Letter No. C4/27377/92

Sub: MMDA - PP - Additional construction of
school building at s. no. 67/1A & 87/4
Block No. 13
of Nungambakkam, Madras - appd -
remittance of D.C. reg.

▲ GROUND FLOOR PLAN  
 DETAILS OF PORTICO

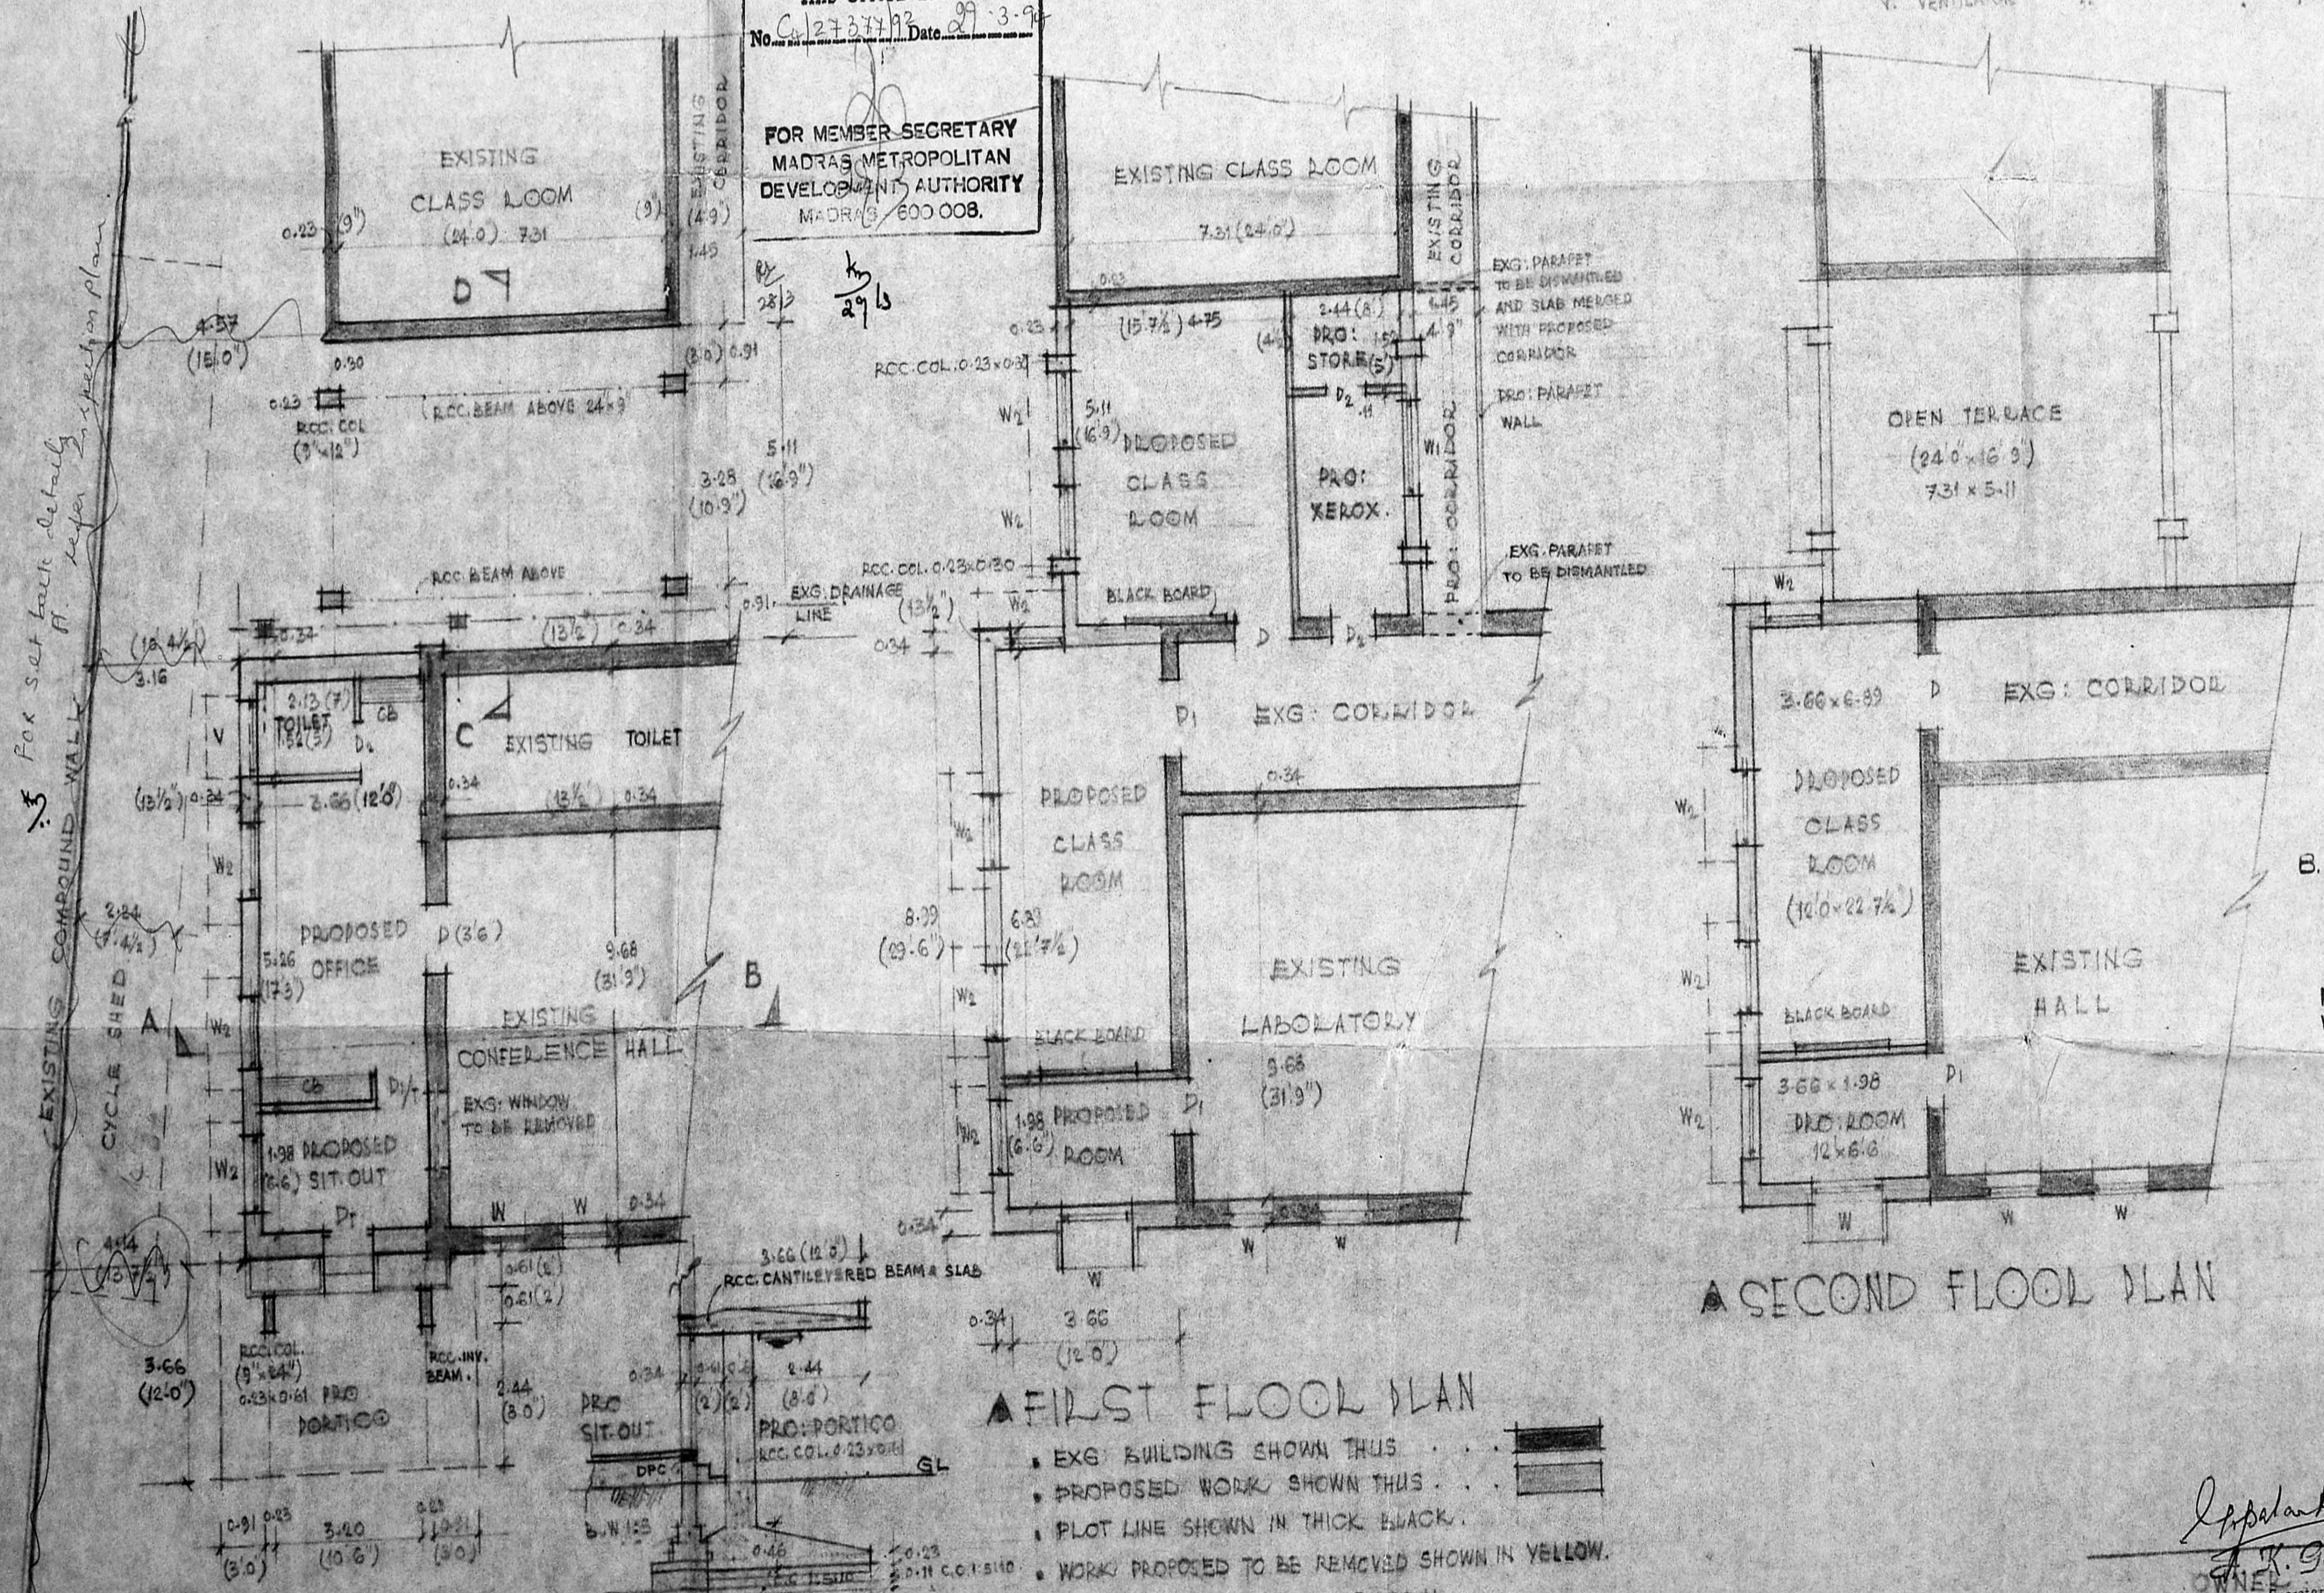
@@ The overall building measurement and setback measurements
for all the existing and proposed building.
